CITY OF ALBUQUERQUE

March 4, 2020

Re: Wecks Restaurant
5115 Central Ave Ne
Traffic Circulation Layout
Engineer's/Architect's Stamp 02-17-20 (k17-d025)

Site Plan

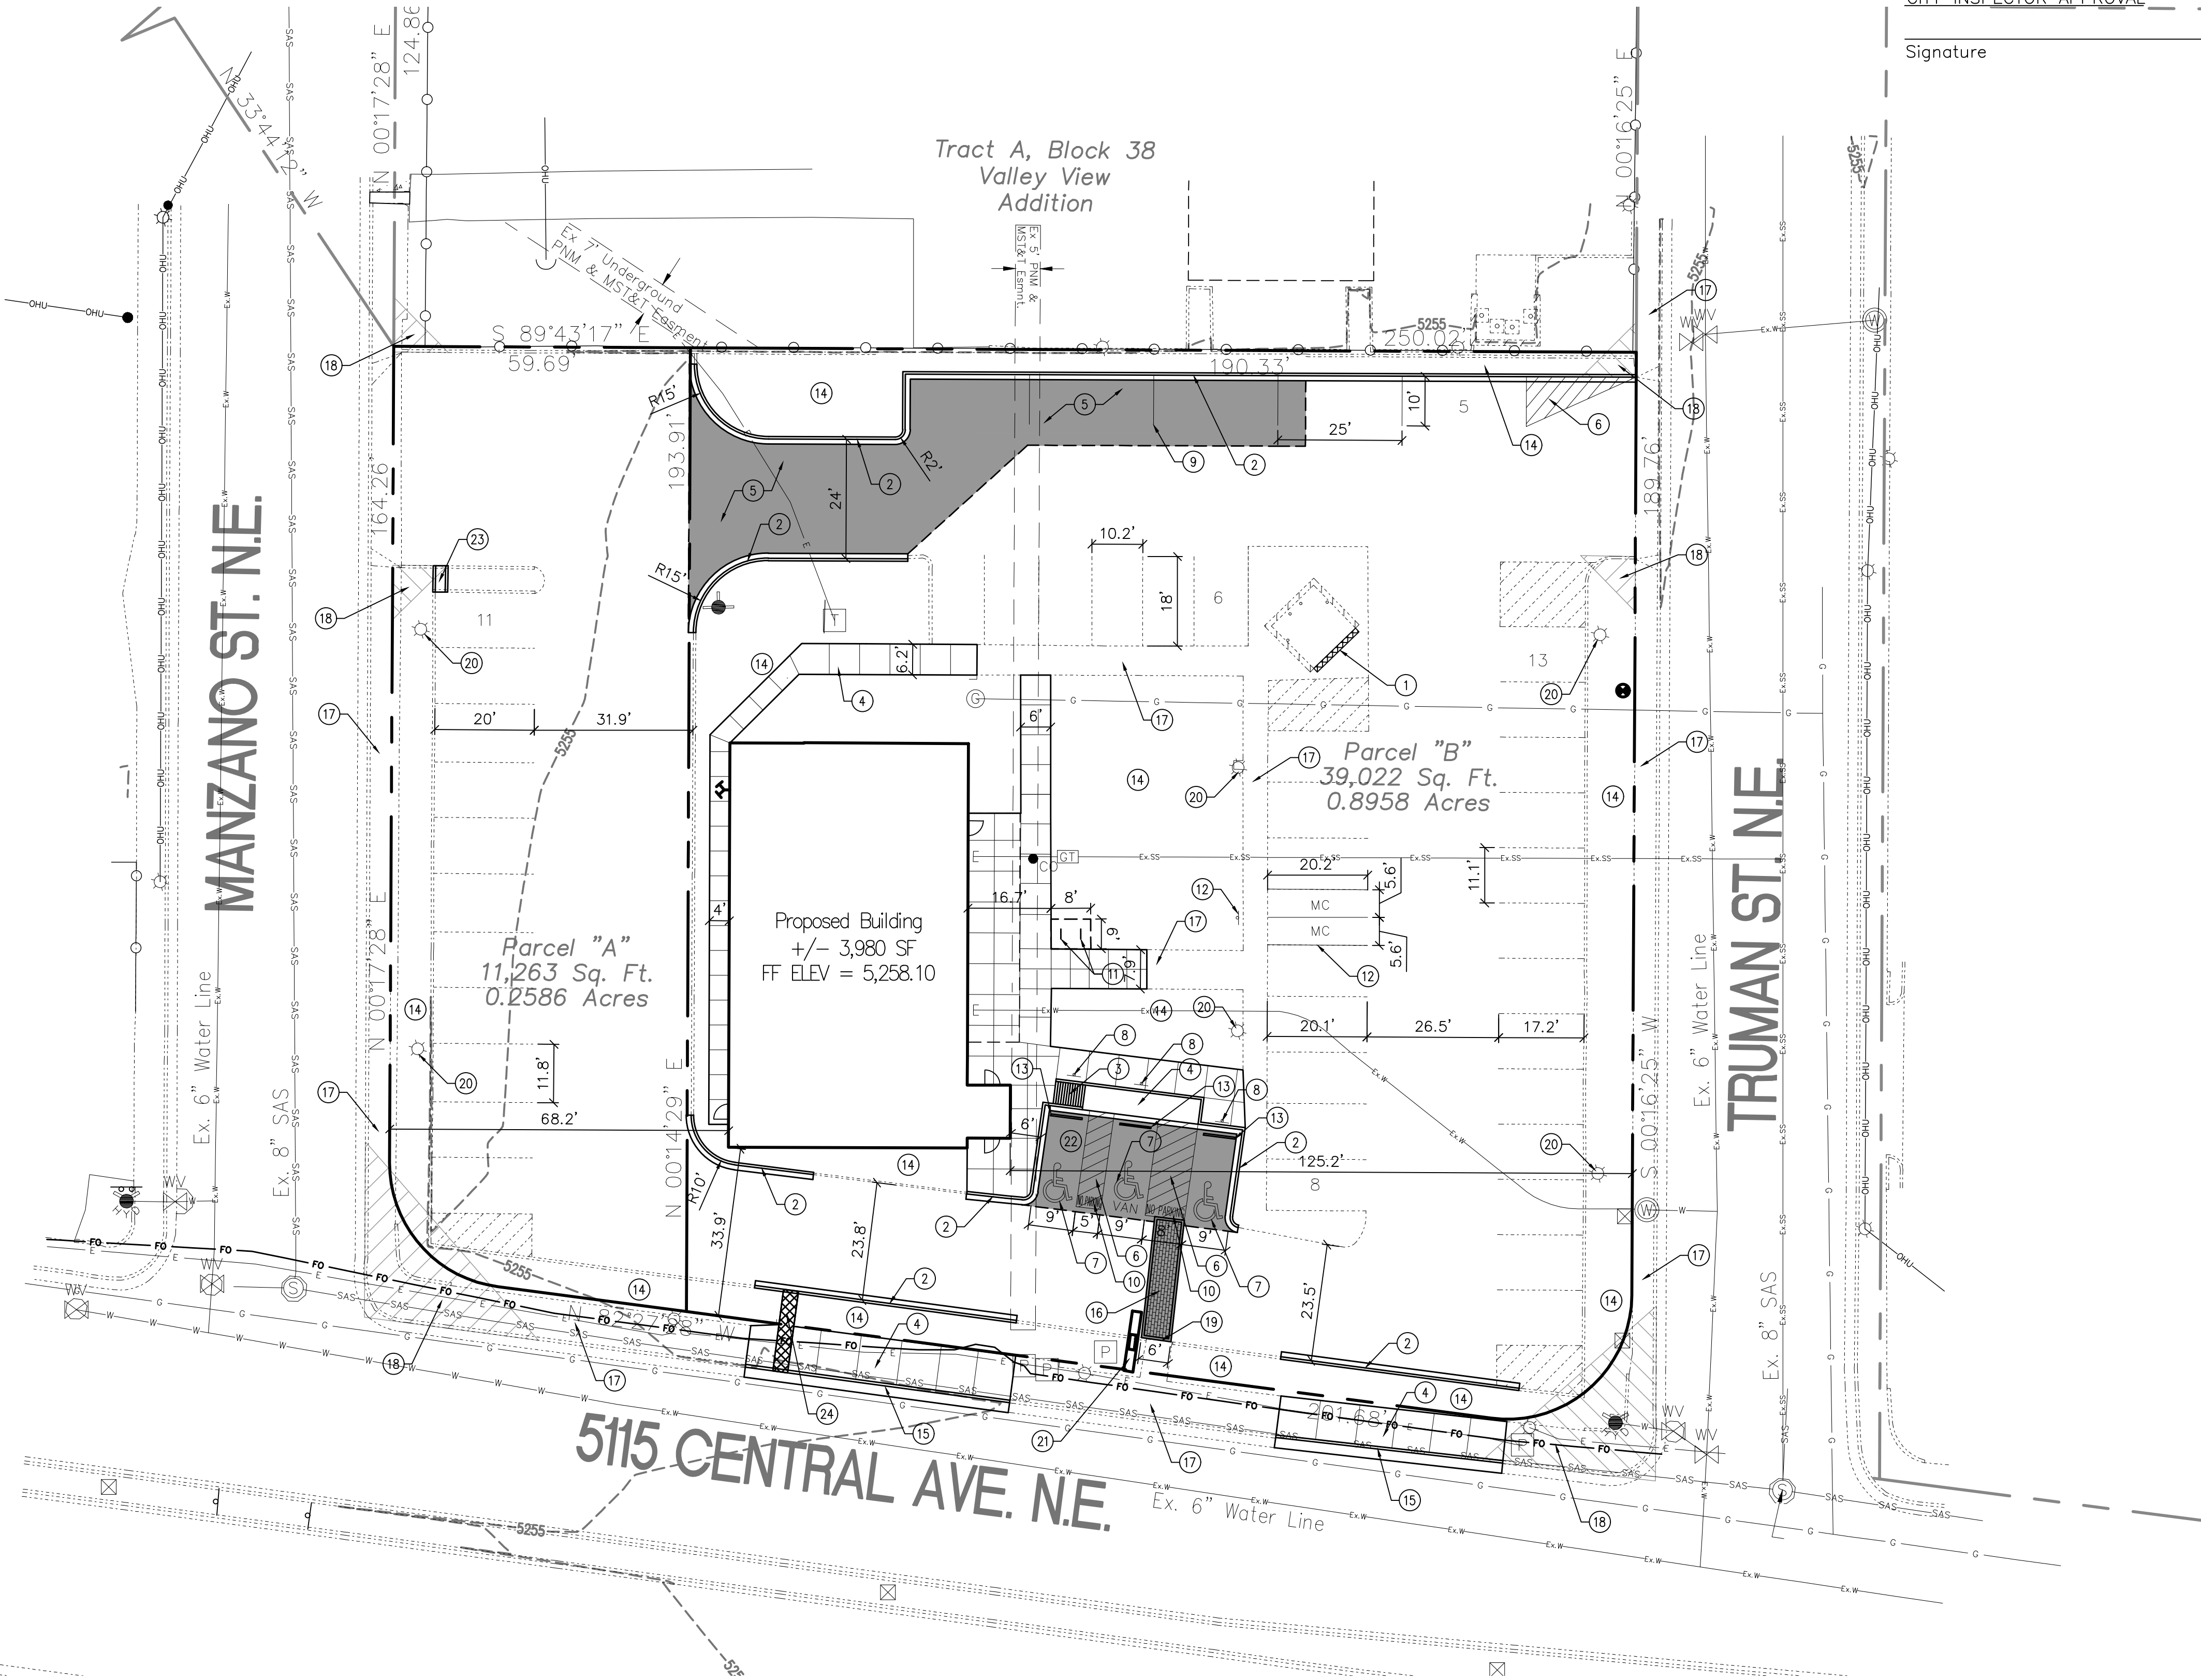
1. Proposed parking calculations need to be coordinated with Zoning.
2. Identify all existing access easements and width dimensions.
3. Please list the length for proposed ADA accessible parking spaces. Some dimensions are not shown.

4. ADA curb ramps must be updated to current COA standards or provide detail.
5. All bicycle racks shall be designed according to the following guidelines:

9. Per the IDO, a 6 ft. wide ADA accessible pedestrian pathway is required from the public sidewalk to the building entrances. Please clearly show this pathway and provide details.

10. Per DPM, a 6 ft. wide ADA accessible pedestrian pathway is required from the ADA parking stall access aisles to the building entrances. Please clearly show this pathway and provide details.

11. ADA accessible pedestrian pathway should not be placed behind parking space or adjacent to a vehicular way. Vehicle and pedestrian/wheel chair conflicts should be avoided as much as possible.

12. All proposed sidewalks and ADA accessible pedestrian pathway dimension/widths need to be shown.
13. Truman Street Driveway: provide a detail of median curb and gutter connection onto existing driveway.

14. Please provide a stopping sight distance exhibit instead of clear sight triangle per DPM chapter 23, Section 3.9.5.
15. Show the clear sight line and add the following note to the plan: "Landscaping and signage will not interfere with clear sight line requirements. Therefore, signs, walls, trees, and shrubbery between 3 and 8 feet tall (as measured from the gutter pan) will not be acceptable in the clear sight line.

18. Add a note stating "All broken or cracked sidewalk and curb & gutter must be replaced with new sidewalk and curb & gutter." A build note must be provided referring to the appropriate City Standard drawings.

Urban Rack (UB-1000-STD)
NTS

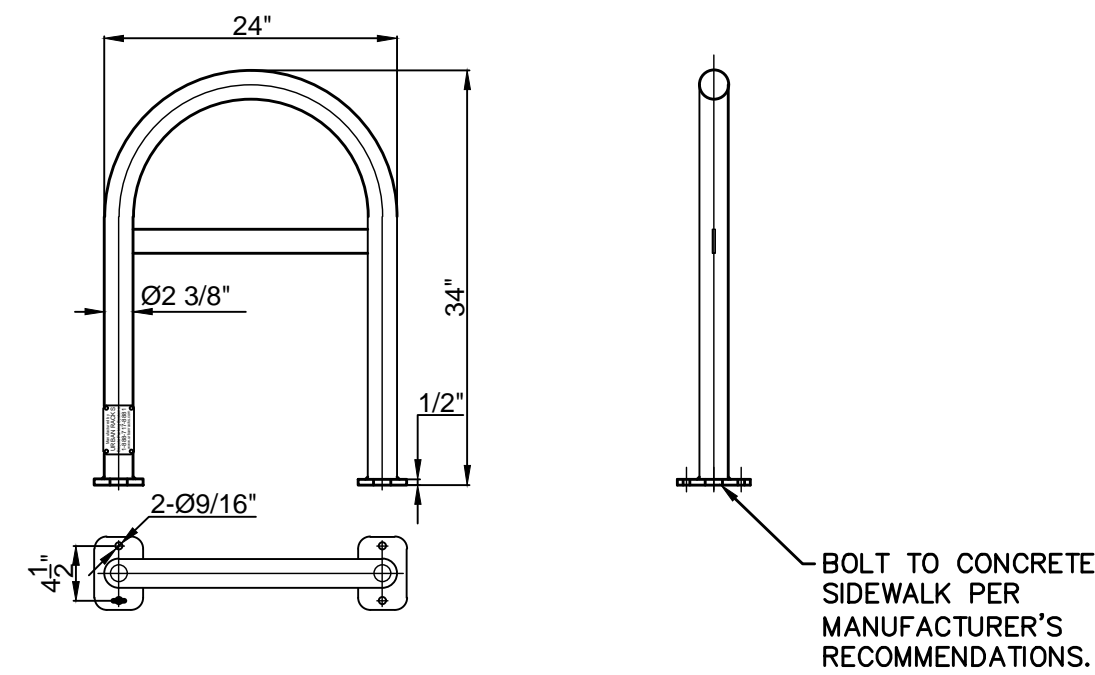
- a. The rack shall be designed to support the bicycle in an upright position. See the IDO for additional information.
 - b. The rack allows varying bicycle frame sizes and styles to be attached.

- c. The user is not required to lift the bicycle onto the bicycle rack.
 - d. Each bicycle parking space is accessible without moving another bicycle.

6. Bicycle racks shall be sturdy and anchored to a concrete pad.
7. A 1-foot clear zone around the bicycle parking stall shall be provided.
8. Bicycle parking spaces shall be at least 6 feet long and 2 feet wide.
